Your Ref: 2024/91199
Our Ref: A002546

31st May 2024

140A, Manchester Road, Longroyd Bridge, Huddersfield, HD1 3JA - Demolition of existing building and erection of student accommodation with ancillary spaces, associated garden area, store and landscaping, access and car parking

SITE PLAN Scale 1:100 0 5m 10m

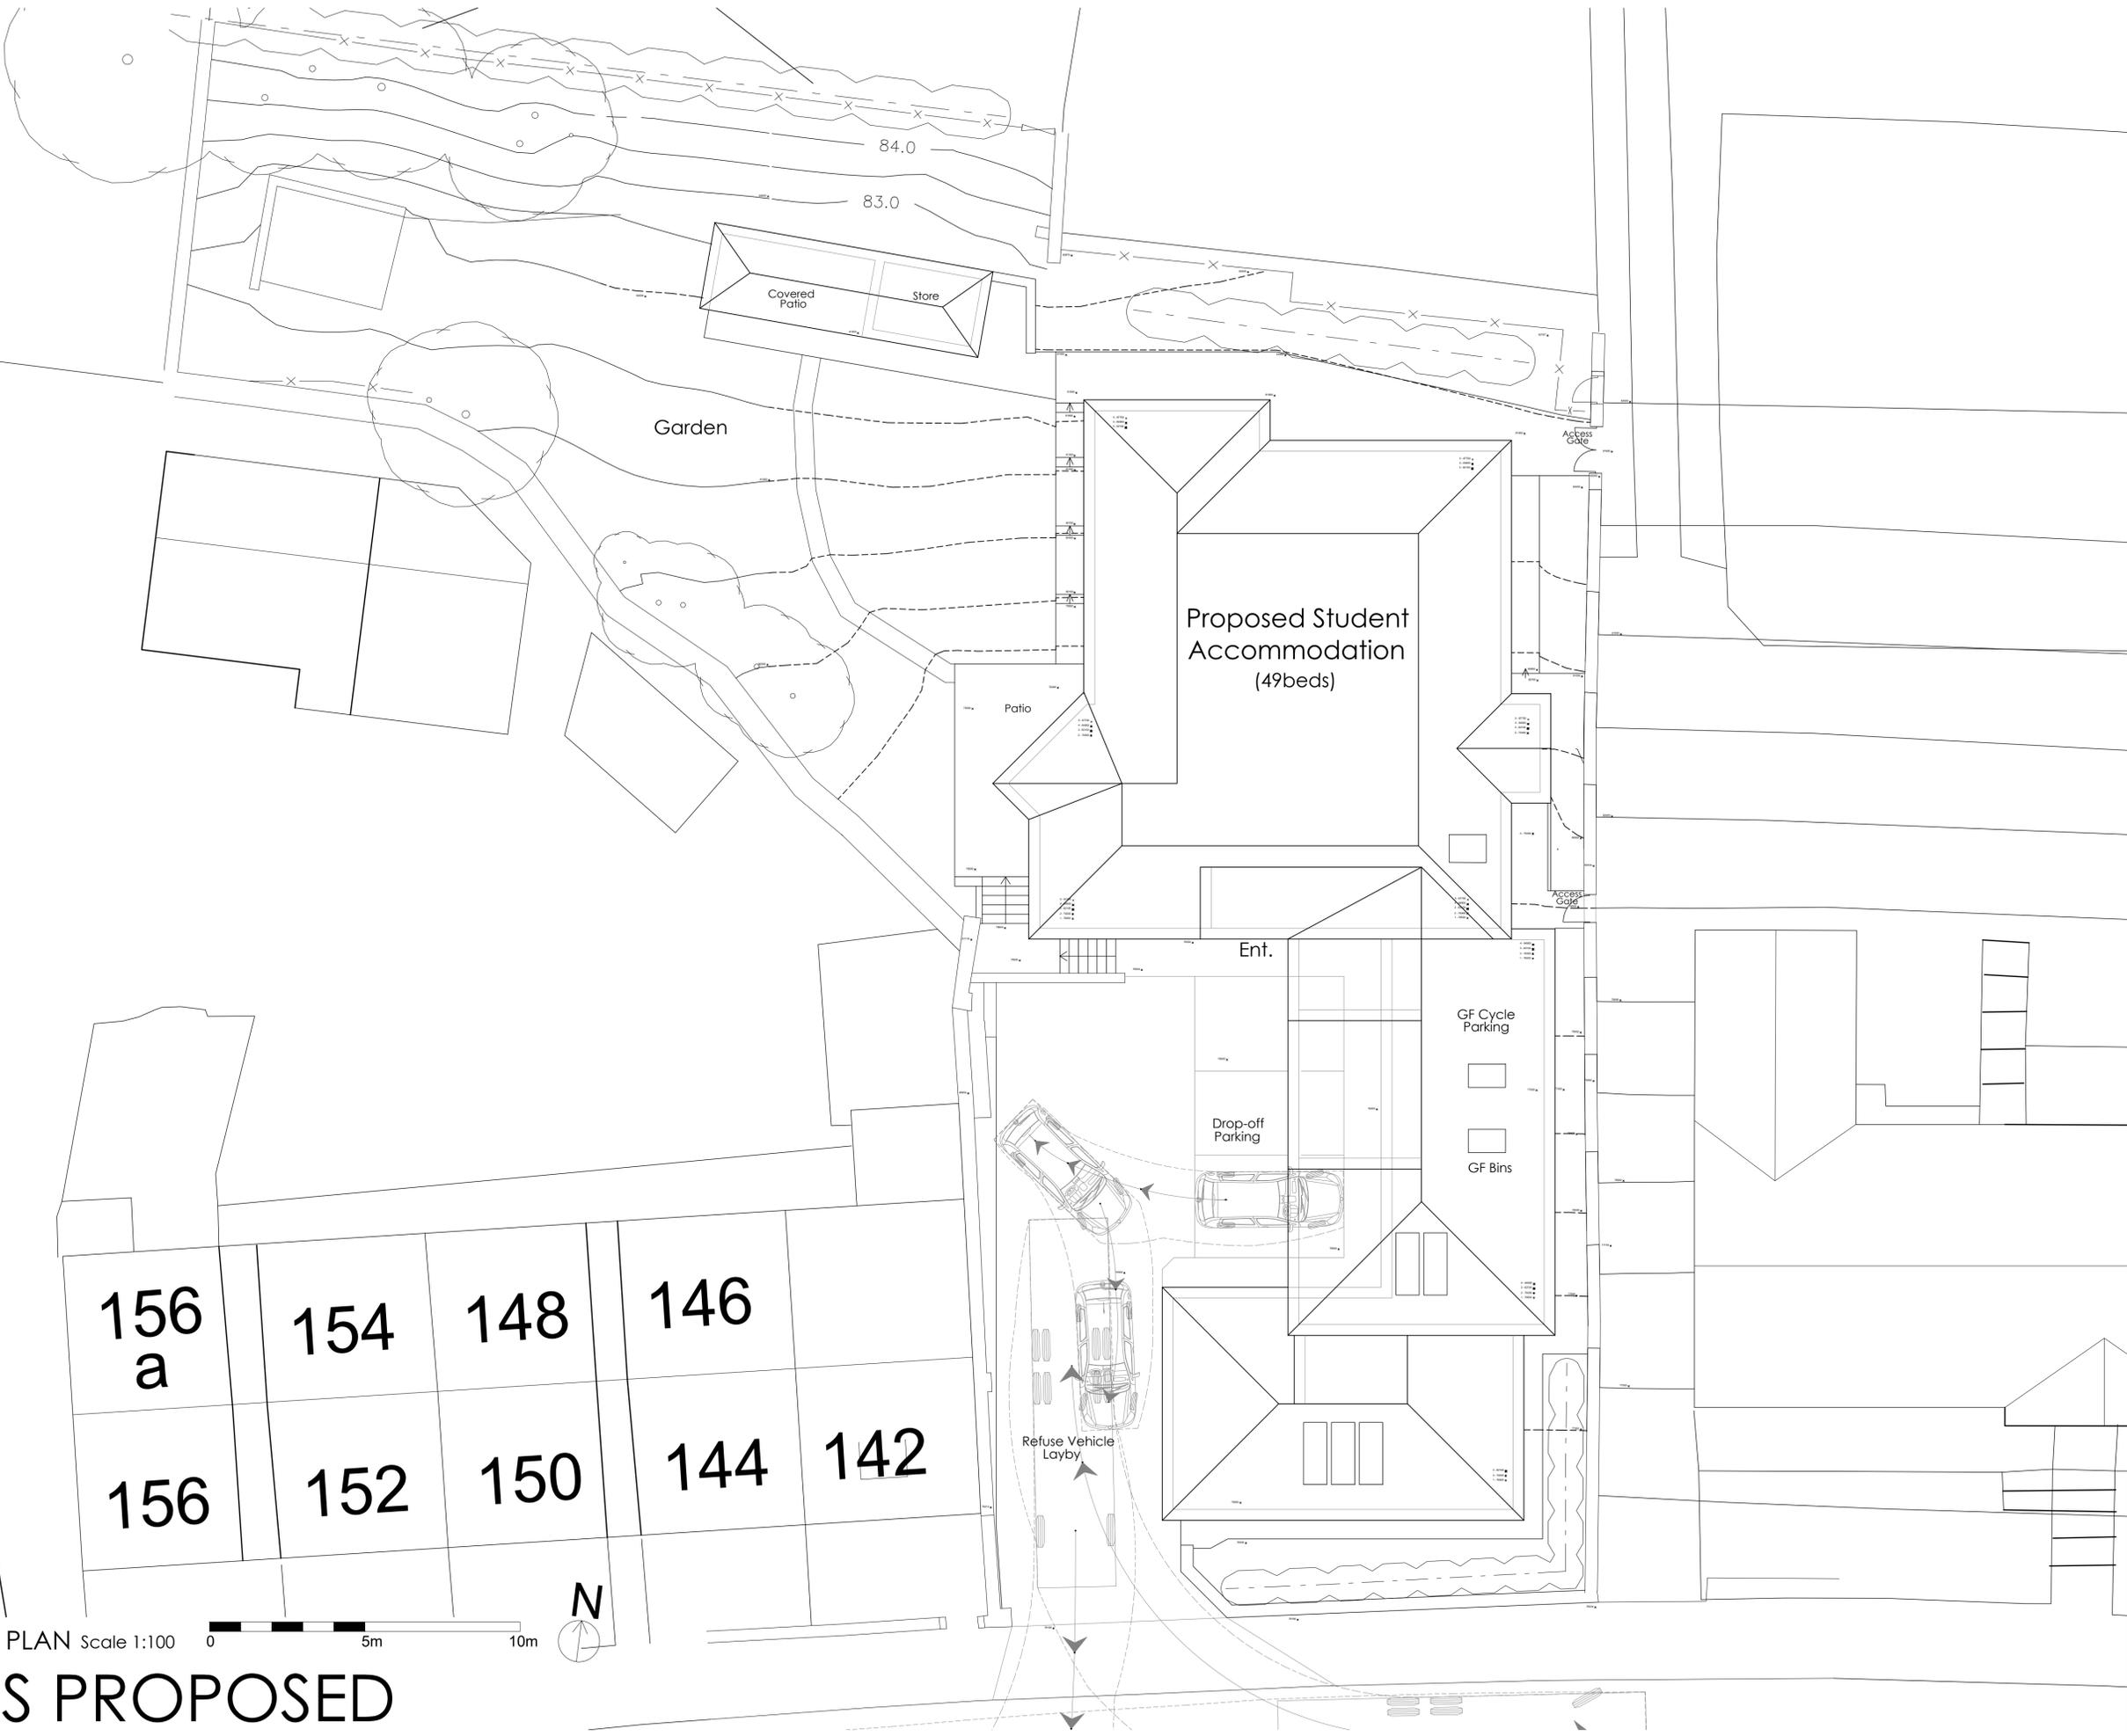
1.) The drainage details submitted on drawing 'ENGINEERING FEASIBILITY' E24/8164/001 dated April 24 that has been prepared by Haigh Huddleston require amendments, but if planning permission is granted, the matter can be dealt with via condition. The following point(s) should be addressed:

- a.) the submitted drawing should show the site-surveyed position of the public sewer crossing the site
- b.) evidence should be submitted to show that other (than discharge to public sewer) means of surface water disposal have been considered and why they have been discounted

2.) On the Statutory Sewer Map, there is a 100mm diameter public combined water sewer recorded to cross the site. It is essential that the presence of this infrastructure is taken into account in the design of the scheme.

- a.) It may not be acceptable to raise or lower ground levels over the sewer and we will not accept any inspection chambers on the sewer to be built over.
- b.) In this instance, Yorkshire Water would look for this matter to be controlled (by Requirement H4 of the Building Regulations 2010).
- c.) A proposal by the developer to alter/divert a public sewer will be subject to Yorkshire Water's requirements and formal procedure in accordance with Section 185 Water Industry Act 1991.
